WEST SUSSEX COUNTY COUNCIL CONSULTATION

TO:	Arun District Council FAO: Ms M Tomalova
FROM:	WSCC Highways - Public Rights of Way
DATE:	13 June 2022
LOCATION:	Salamanda 37 Coastal Road Littlehampton BN16 1SJ
SUBJECT:	K/11/22/PL Demolition and erection of 1 No detached dwelling. This site is in CIL Zone 4 and is CIL Liable as new dwelling.
DATE OF SITE VISIT:	n/a
RELEVANT PUBLIC RIGHTS OF WAY NUMBER(S):	Byway 3623
RECOMMENDATION:	objection
S106 CONBUTION TOTAL:	n/a

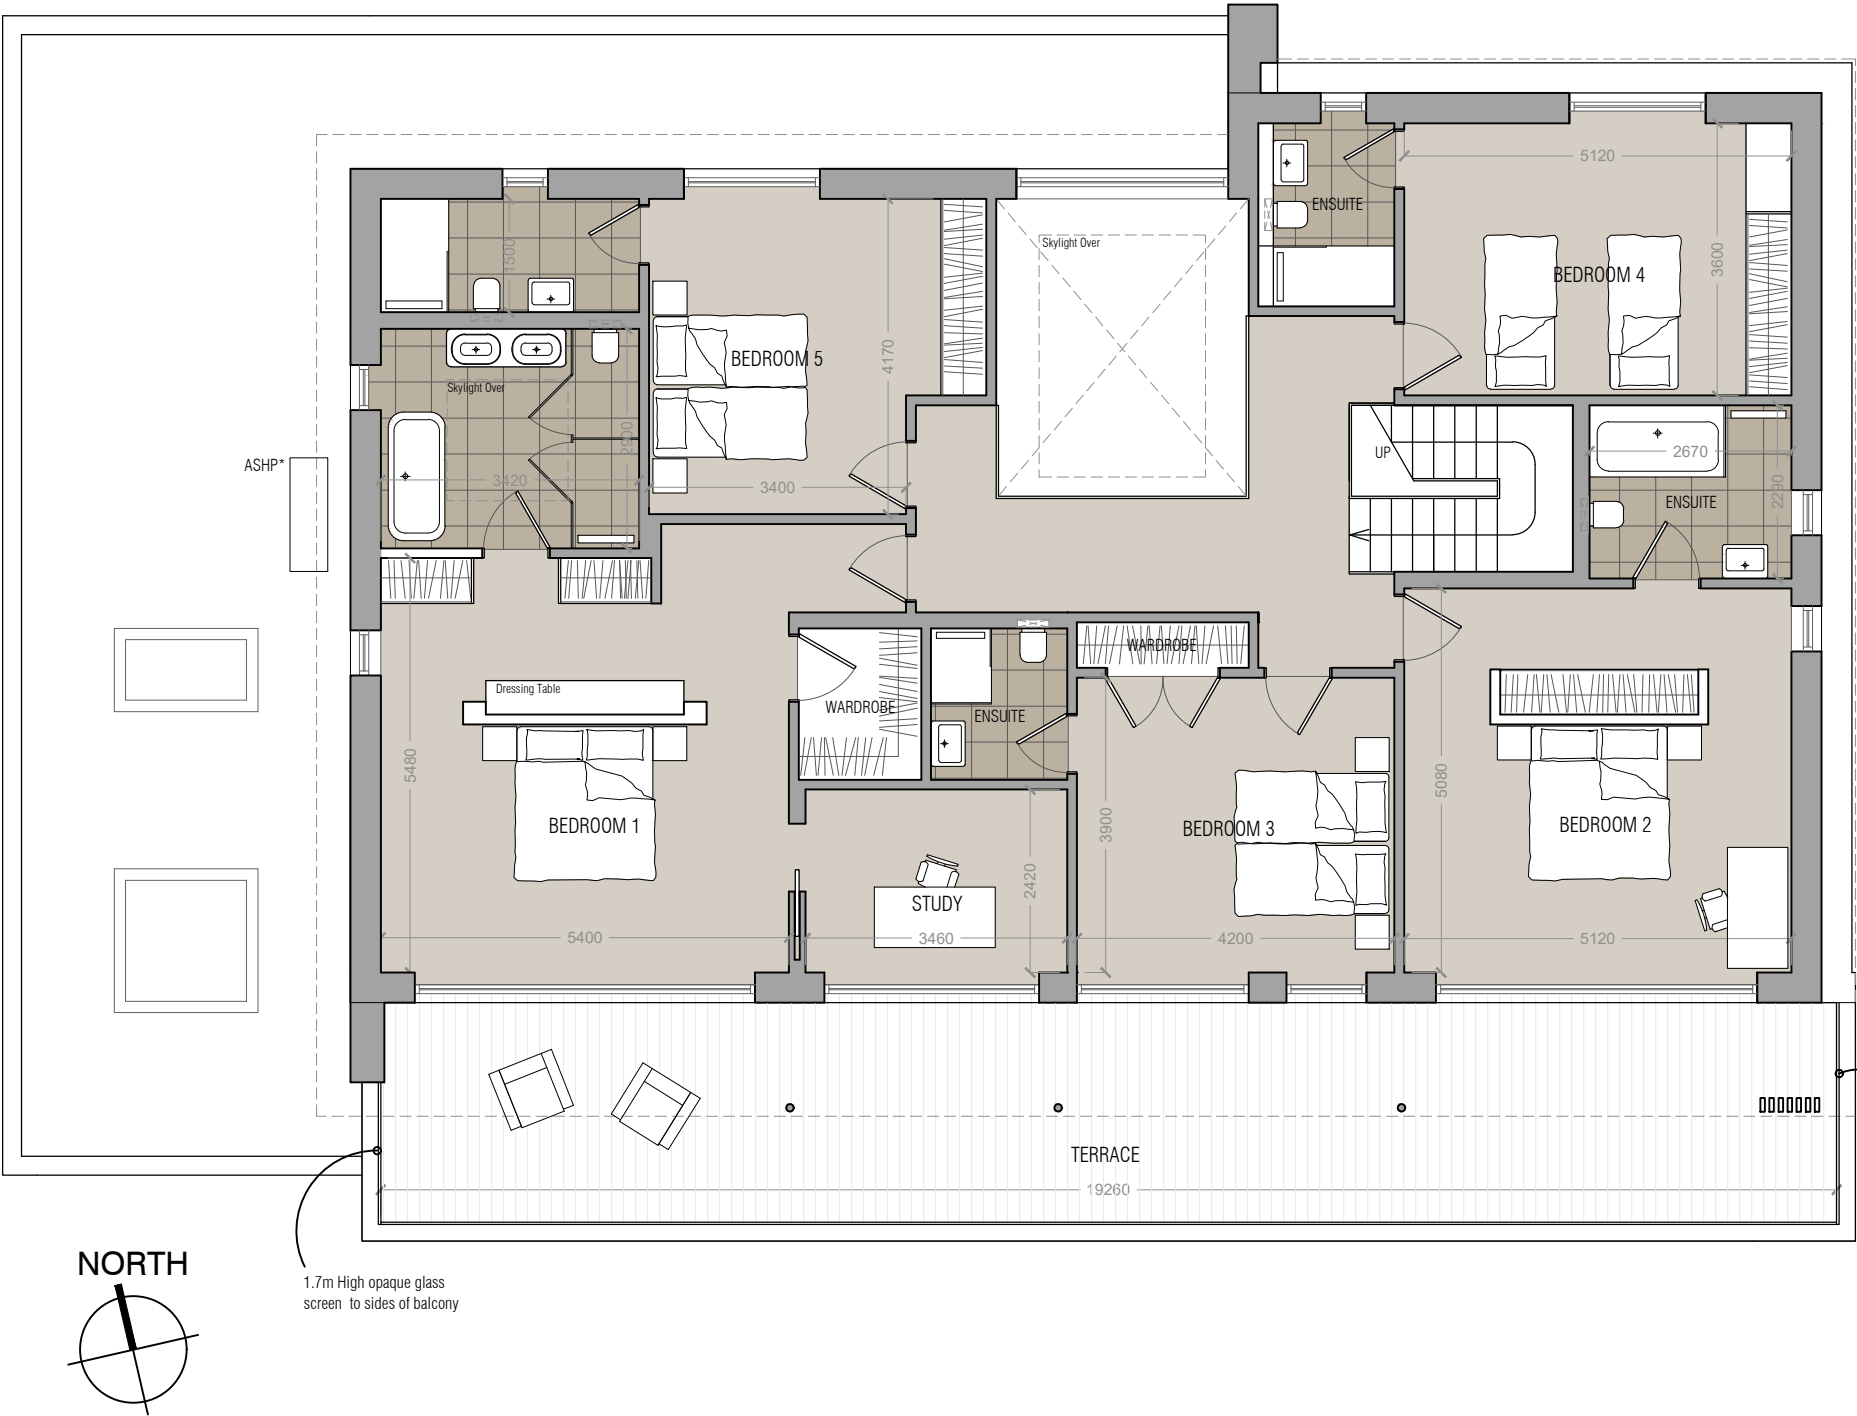
The proposed development is on the west side of Byway 3623 and from the submitted plans it appears the development will directly affect Byway 3623, also known as Peak Lane, by encroaching onto the definitive width of the PROW, and for this reason, PROW object to this application.

In 2020 this issue was brought to our attention again and in order to formalise the position the County Council placed notes on the land charges register identifying the properties in the section of Byway 3623 to the north of Coastal Road, as identified in 1996, who are occupying part of the highway and maintaining it. The purpose of Land Charges notes is to make it clear to potential future purchasers that the areas maintained form part of the publicly maintainable highway. At this time notes were not made on the Land Charges Register regarding effected properties adjacent to Byway 3623 to the south of Coastal Road, but regardless of this the property Salamander does occupy and maintain part of the public highway.

Whilst writing, I should also point out that Byway 3623, including the areas identified as being maintained by adjoining owners, is a public highway and that highway rights, limited to those on foot, horseback and bicycle extend across its full historic width. Any future changes to, or work along Byway 3623 will need the consent of West Sussex County Council as highway authority. Therefore, in order to build upon land that forms part of the highway the landowner will need to either 1) apply for a stopping up order or 2) apply for a diversion under S257 Town & Country Planning Act. Enquiries concerning this should be directed to the Public Rights of Way team.
